**From:** Mike Smith <smithm@ci.ellensburg.wa.us>  
**Sent:** Monday, August 27, 2012 3:34 PM  
**To:** Jeff Watson  
**Subject:** RE: BL-12-00014 Juniper Village

**From:** Jeff Watson [mailto:[jeff.watson@co.kittitas.wa.us](mailto:jeff.watson@co.kittitas.wa.us)]  
**Sent:** Friday, August 24, 2012 10:37 AM  
**To:** Mike Smith; Lance Bailey  
**Subject:** BL-12-00014 Juniper Village

**From:** Jeff Watson  
**Sent:** Wednesday, June 27, 2012 11:10 AM  
**To:** Larry Browne ([eburgwater@yahoo.com](mailto:eburgwater@yahoo.com))  
**Cc:** Mike Smith ([smithm@ci.ellensburg.wa.us](mailto:smithm@ci.ellensburg.wa.us)); [baileyl@ci.ellensburg.wa.us](mailto:baileyl@ci.ellensburg.wa.us); Christine M. Garcia  
**Subject:** BL-12-00014 Juniper Village

Proposed Configuration

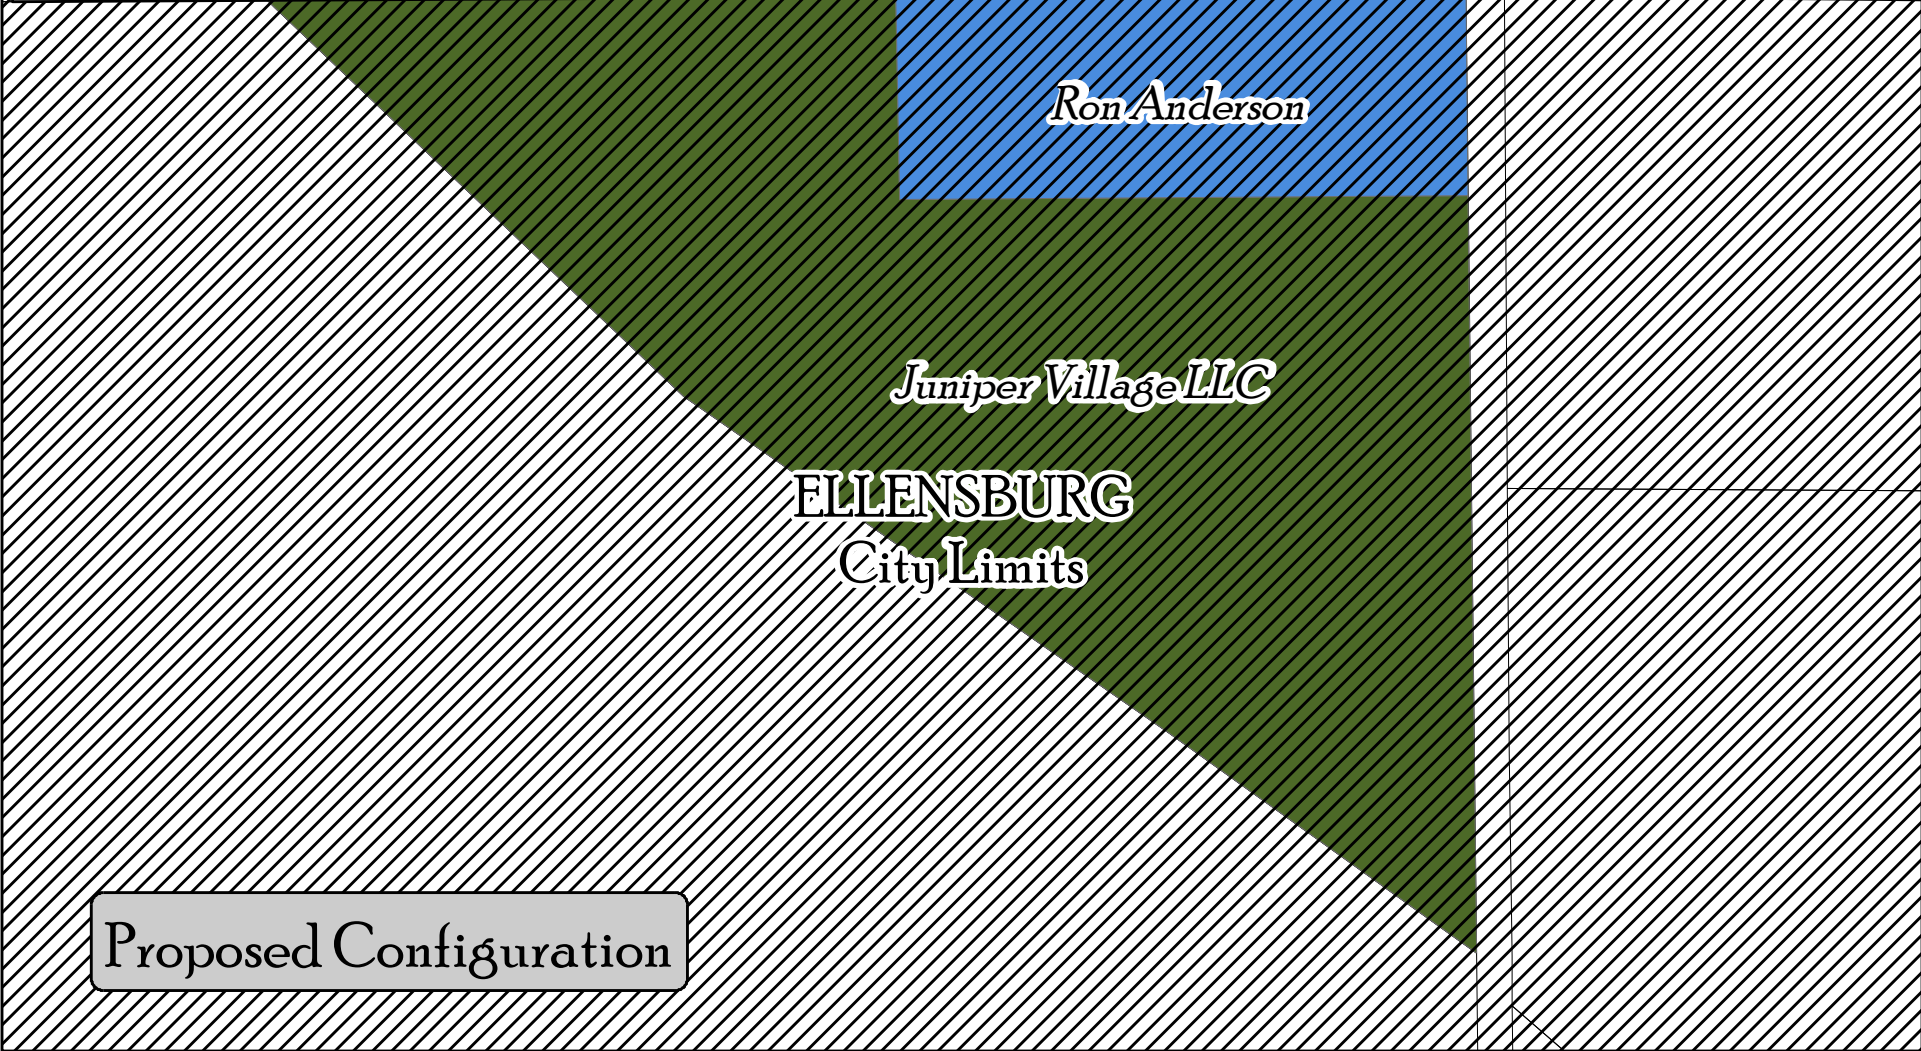
We really have to significant objections to this other than it does not make for good planning with a portion of a property being under City jurisdiction and a portion being under County jurisdiction. But I see nothing that would make the BLA unapprovable.

The zoning on the two sites is also problematic with the City side being medium density and the County side being Urban Residential I think and the surrounding unincorporated area being Contract General Commercial.

Any future development of the City portion will require improved access which means Pott Road would have to be upgraded or some other means of access meeting City standards would be necessary.

Long and short is that unless they eventually want to short plat it (which will trigger road improvements) the newly created lot will be problematic to administer for both City and County and it will be difficult for the owner to develop in a way that works.
